HINCKLEY NATIONAL RAIL FREIGHT INTERCHANGE

Applicant's Response to Deadline 4 Submissions [part 11 – Response to Mr Moore and Dr Moore]

Document reference: 18.17

9 February 2024

NMP4

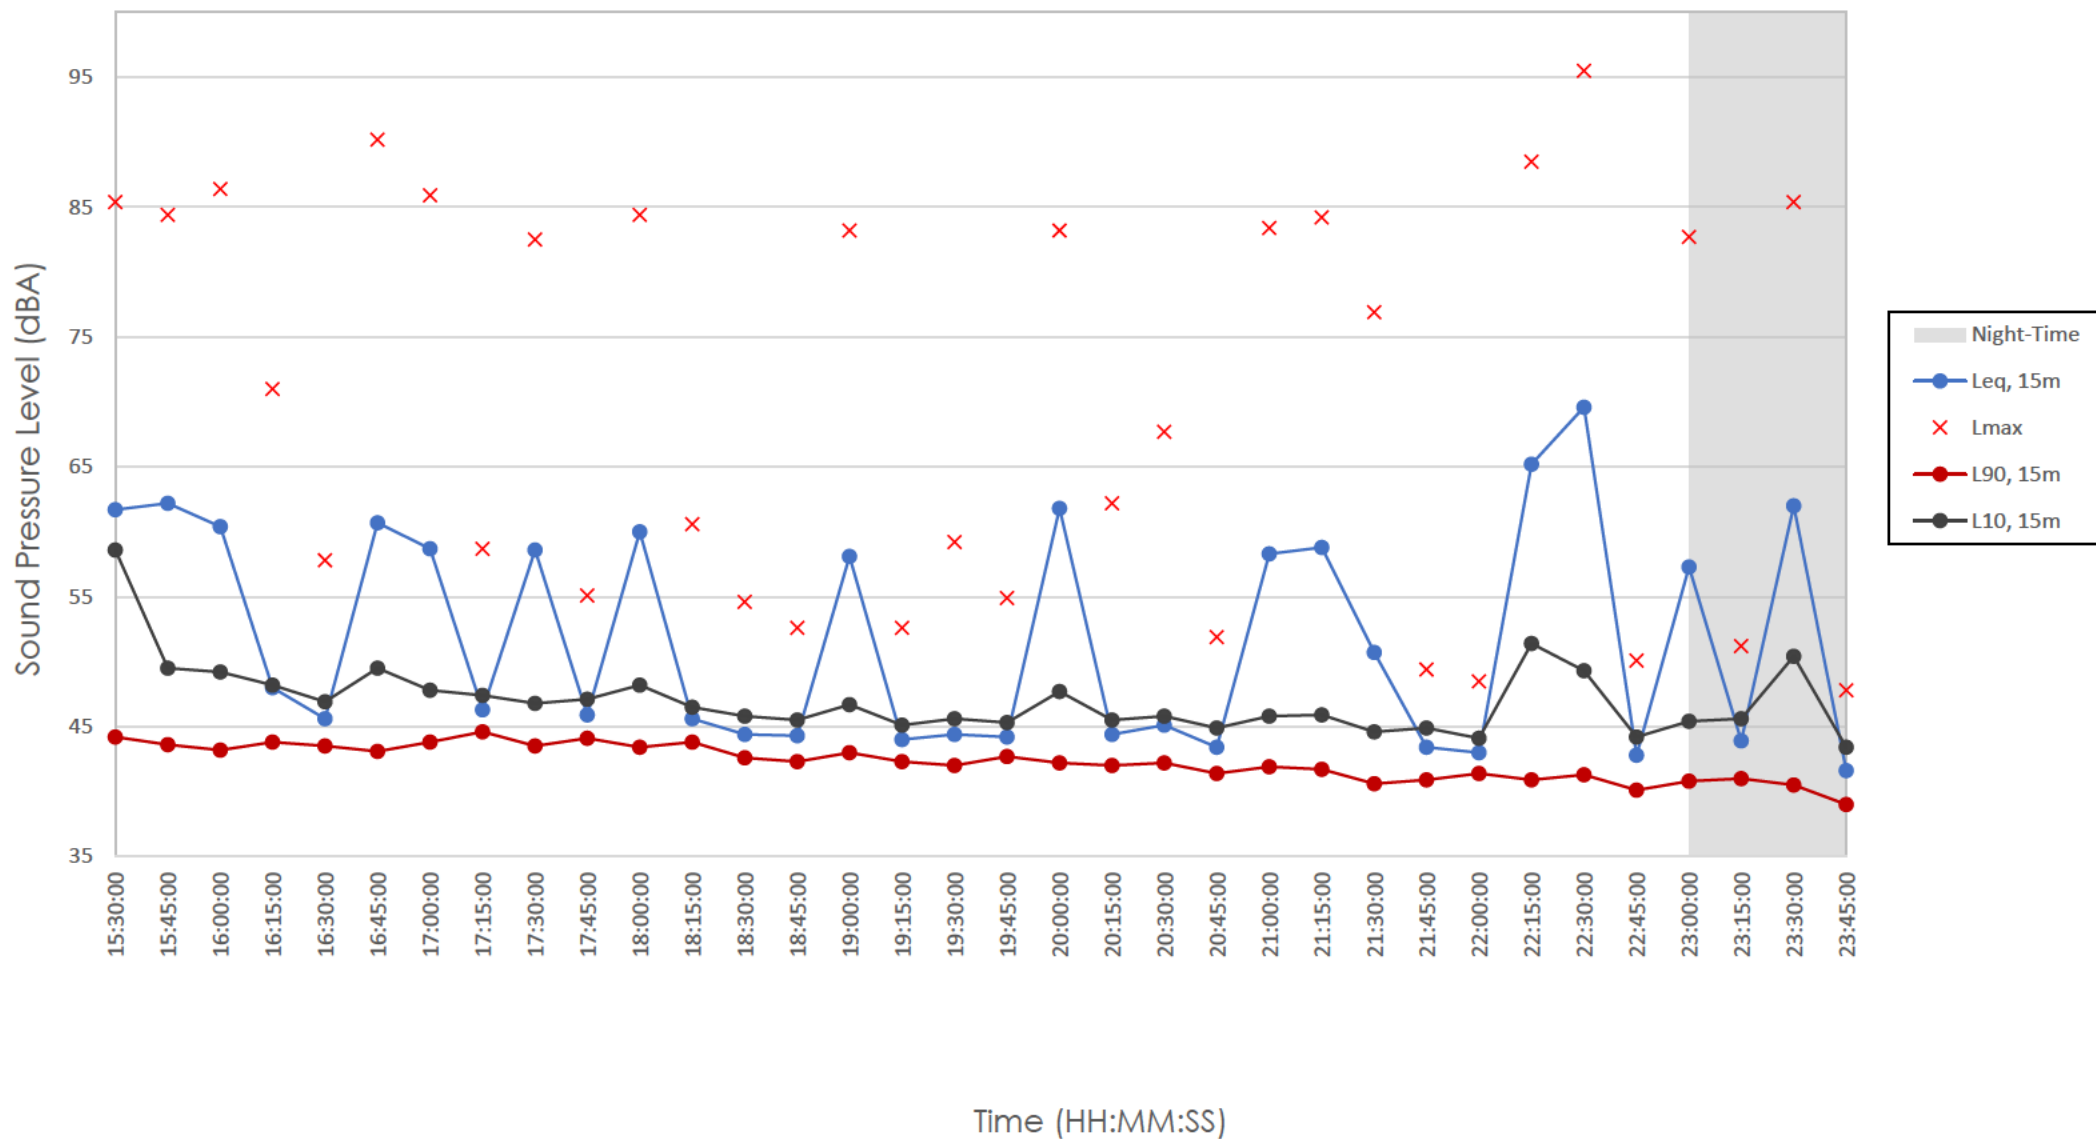
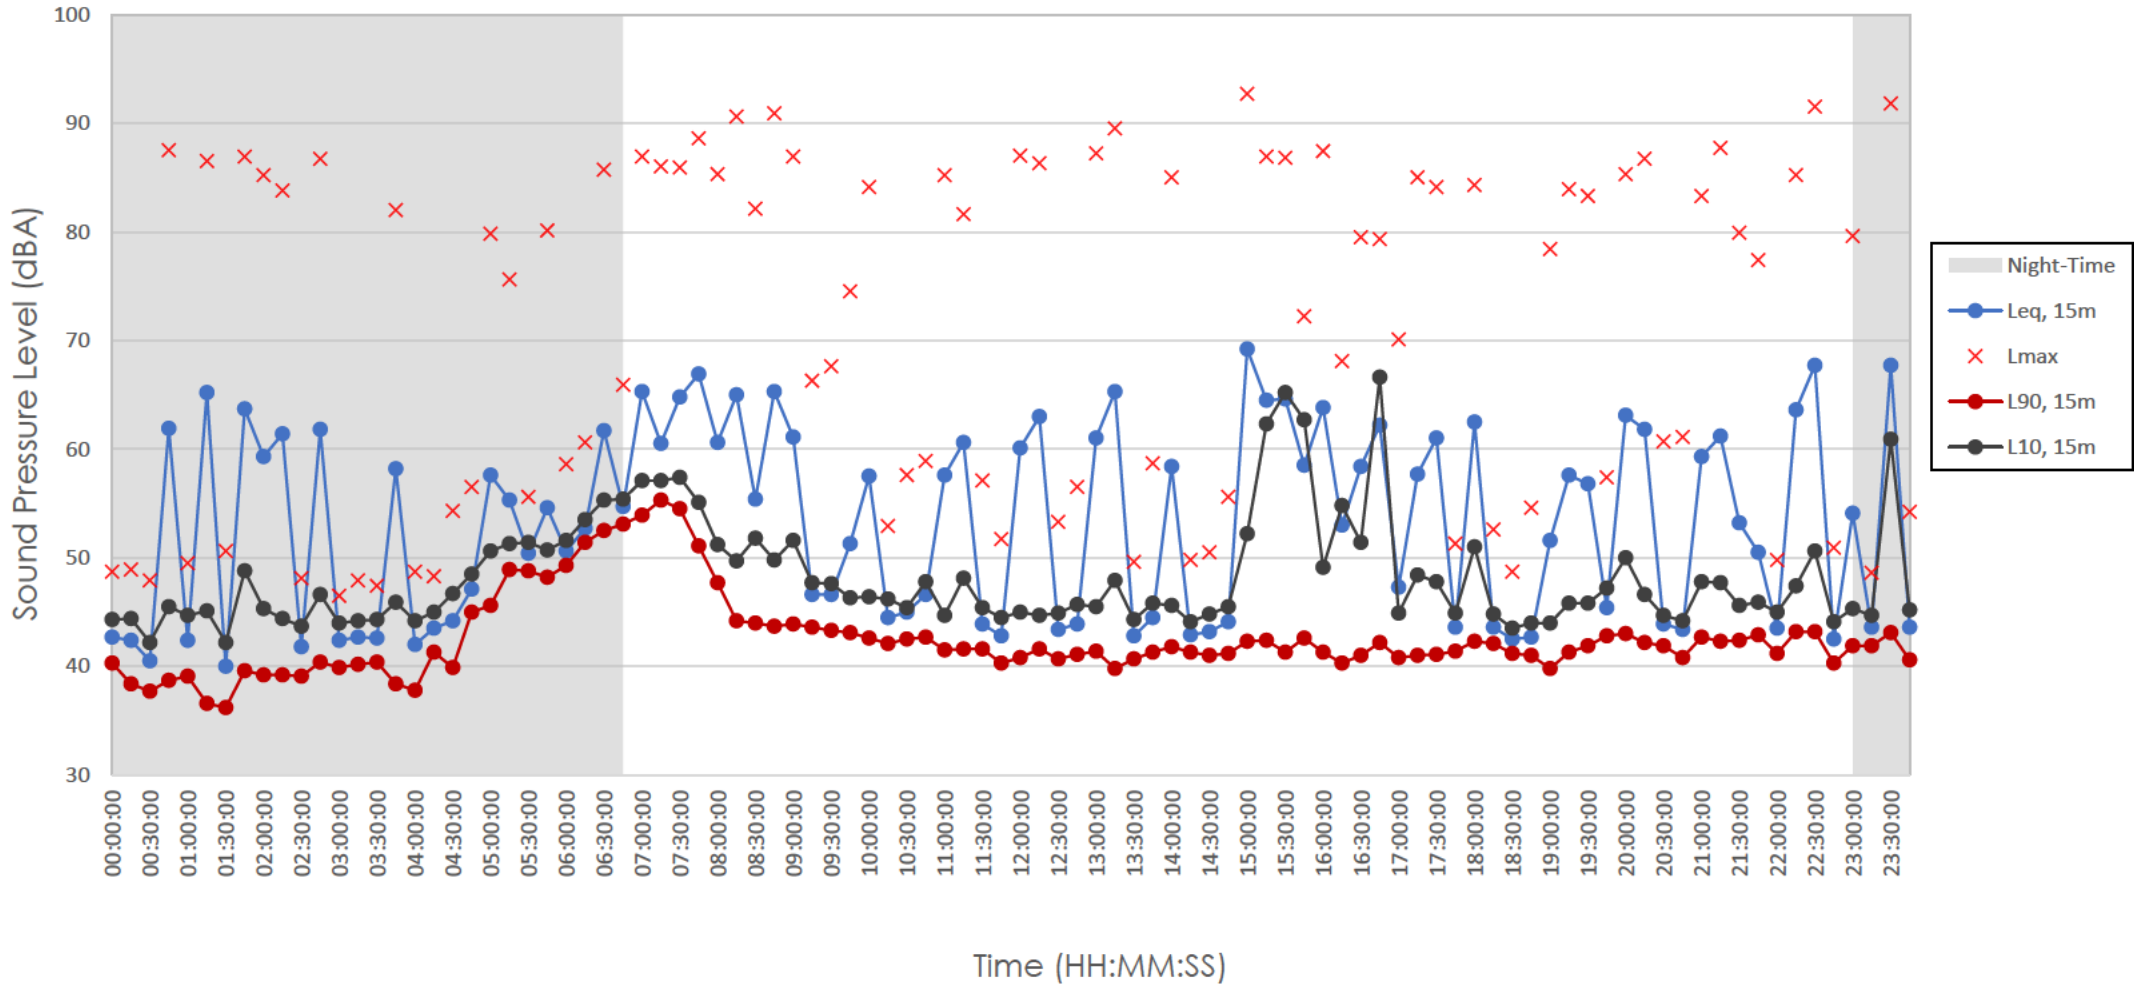
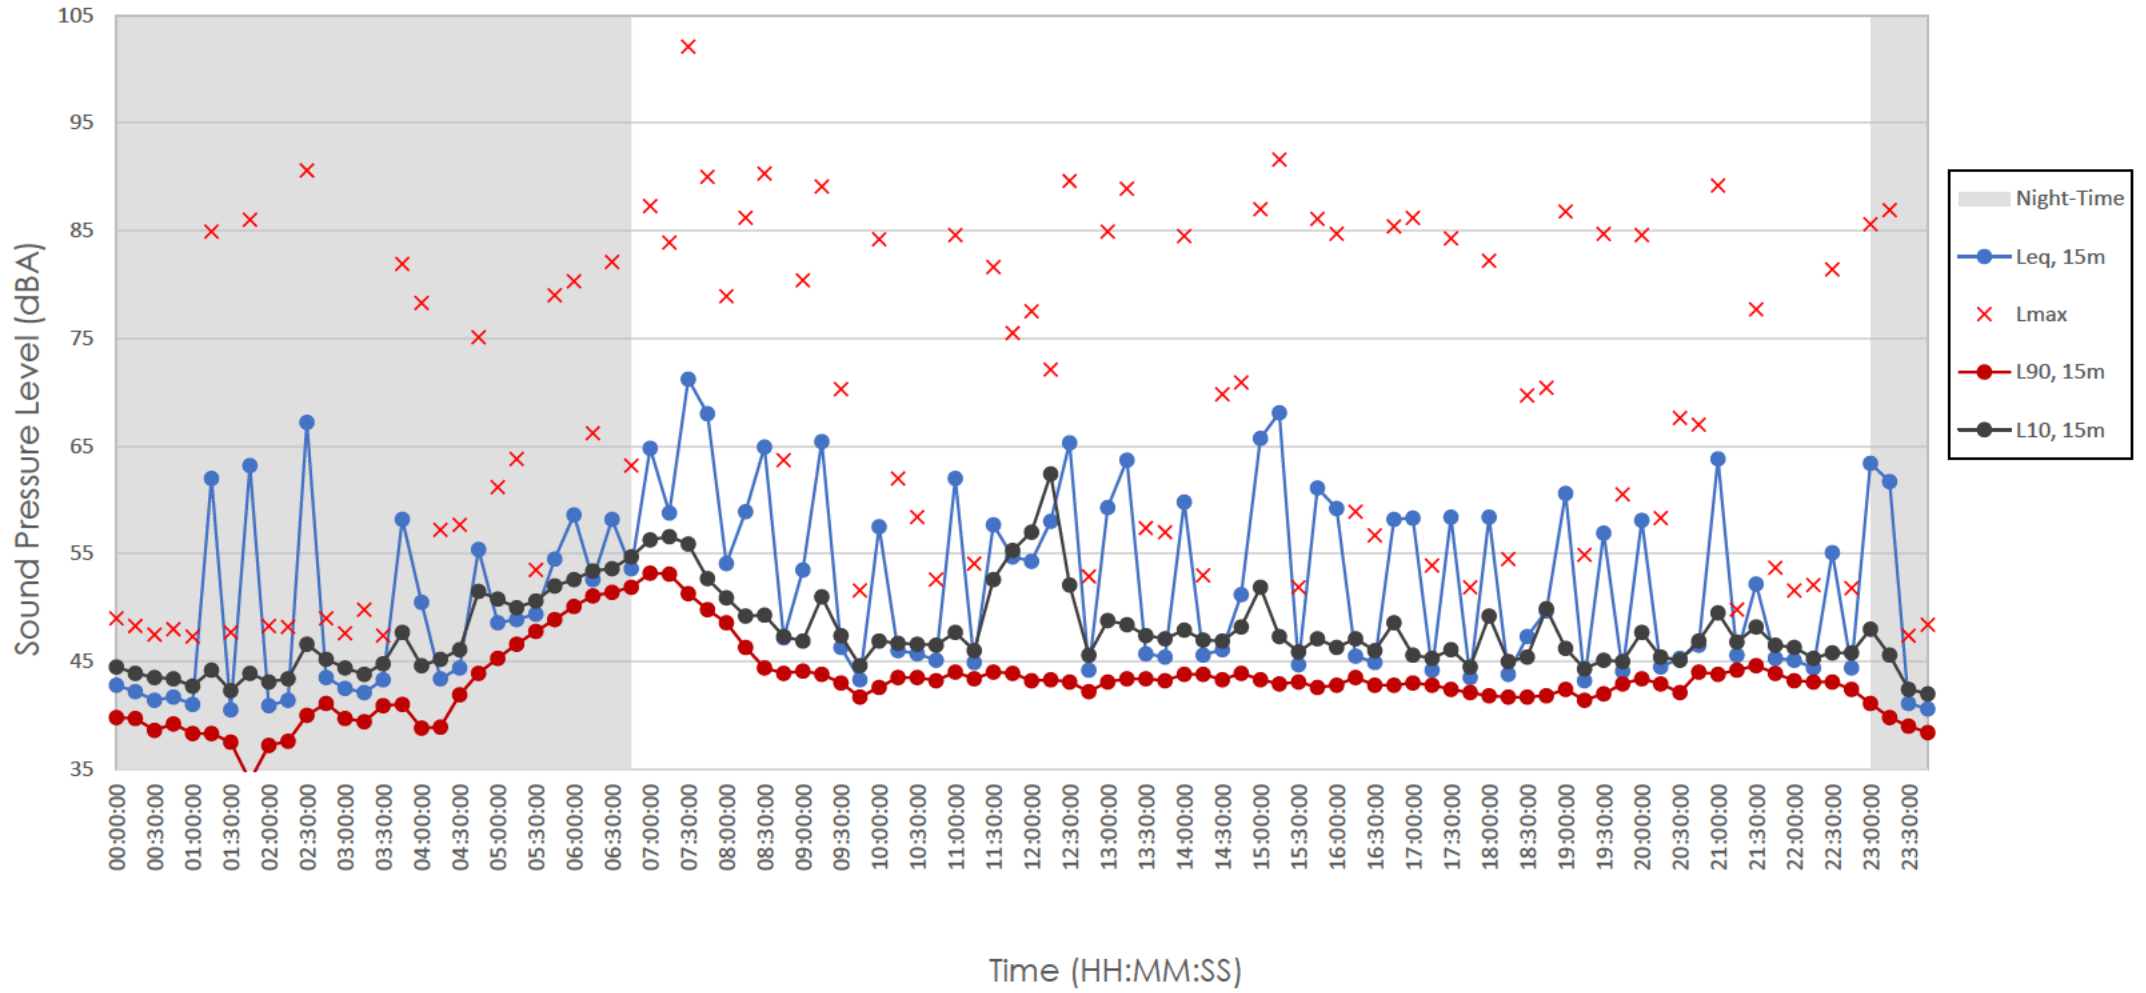
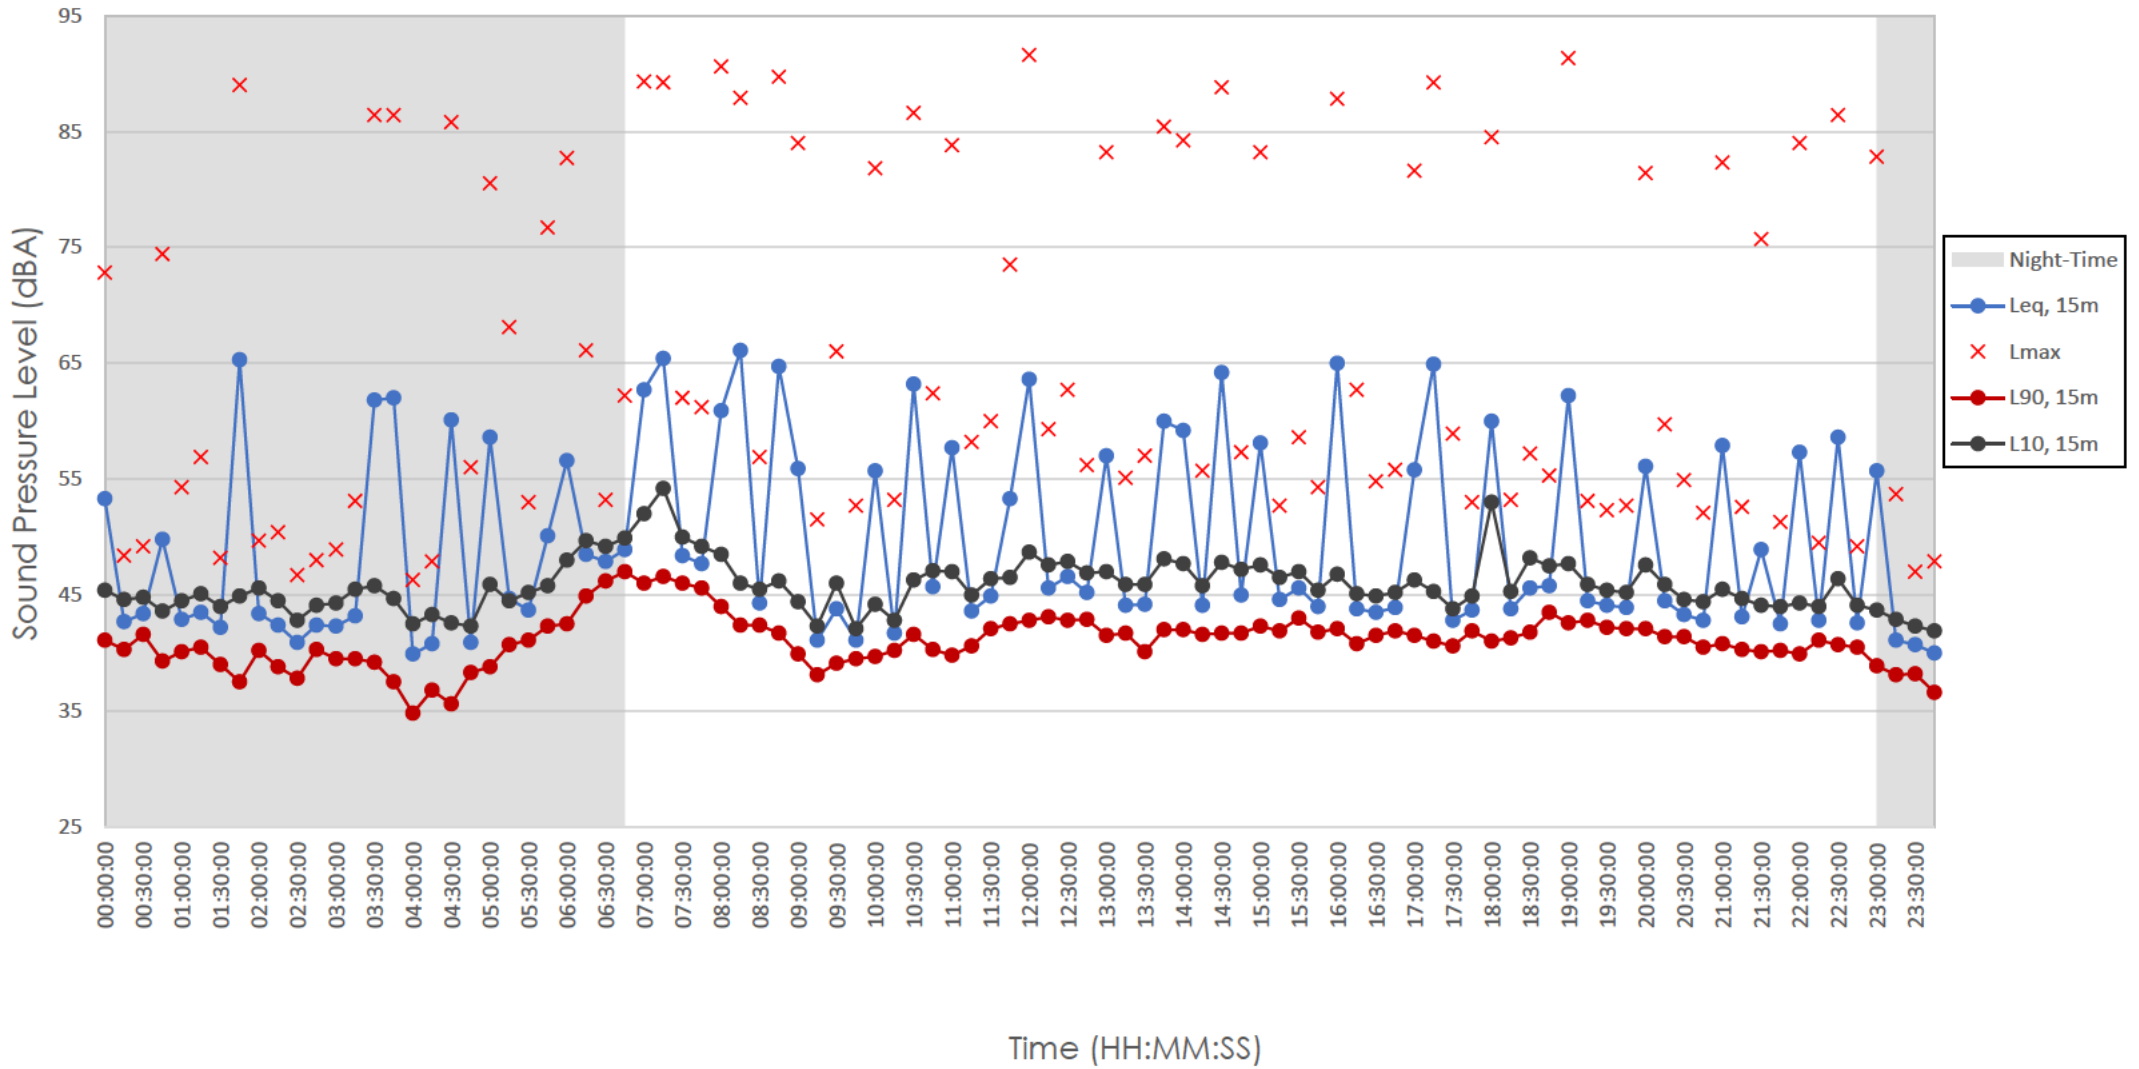
The applicant has submitted a document titled Written Statement of Oral Case ISH3 [Appendix F - Noise Assessment Update Note]. In a roundabout way, the applicant's document attempts to justify the absence of attenuation corrections to the sound of train pass bys measured by NMP4. Rail noise dominates NMP4's ambient sound levels The ambient sound levels measured by NMP4 are utterly dominated by sound of extremely close proximity train pass bys with far lower sound levels when trains aren't passing by, i.e. almost all the time. Overwhelming evidence of this is contained within the summary results pages for NMP4, as explained below in points 1-4. An example summary results page is included in Figure 1, below.

Matter	Applicant's Response
	<p>1. The LAeq sound levels repeatedly spike up and down throughout the daytime and night-time by ~15-20 dB from the low-mid forties, up to 55-65 dB. These spikes are caused by the sound of extremely close proximity train pass bys. Distant road noise would not cause these repeated spikes.</p>	<p>To provide context around the likely existing noise levels from road traffic on the surrounding roads, the baseline 2019 noise model has been reviewed which is based on baseline 2019 traffic data provided by BWB. This does not include any development traffic and purely relates to the existing baseline traffic for 2019.</p>
	<p>2. If these high LAeq sound levels were caused by the distant road noise we would always see the LA10 levels spiking along with the LAeq levels, but we don't because they're caused by train pass bys and train pass bys are inherently brief.</p>	<p>The model only includes those roads that are within the study area for noise and therefore does not include all of the surrounding roads.</p>

<p>3. If these spikes were caused by changes in the distant road noise, we would see significant changes up and down in LA90 levels, but we don't because they're caused by train pass bys and train pass bys are inherently brief. This is why there's a gap of 20 dB between the weekday daytime background sound level in the report and the weekday daytime ambient sound level in the report. The train pass bys have no impact on the measured background sound levels, which contain the distant road noise. This is why NMP4's measured background sound levels can simply be copied to NSRs 1-8 & 24-26.</p>	<p>Using these two sources, it is possible to determine the ambient noise levels in the vicinity of receptors located further away from the railway line, by essentially logarithmically summing the noise level from the rail line with the noise level as a result of road traffic. The results of this calculation are shown in Table 4 within Written Statement of Oral Case ISH3 [Appendix F - Noise Assessment Update Note] (document reference: 18.7.6, REP3-061)</p>

<p>4. The spread between the LA90 levels, LAeq levels, and LA10 levels is very tight in those 15 minute periods which don't contain spikes in LAeq levels. This is because these time periods are dominated by the distant road noise in the low-mid forties dB. The gap between the LA90 levels and the LA10 levels remains stable during periods with spikes in LAeq levels because the distant road noise is stable.</p>	<p>This analysis indicates that as distance increases from the rail line, road traffic from surrounding roads becomes more dominant. The predicted cumulative noise levels from these sources are within an acceptable range (1dB) of noise levels used within the assessment, and therefore the results and conclusions stated within Chapter 10 Noise and Vibration (document reference: 6.1.10A, REP4-039), remain valid.</p>

A response to this question was provided at Deadline 3 and is detailed within Written Statement of Oral Case ISH3 [Appendix F - Noise Assessment Update Note] (document 18.7.6, REP3-061). The response is summarised below.

The latest available DEFRA noise mapping data for the rail line has been reviewed and aligns with the noise levels measured at NMP4.
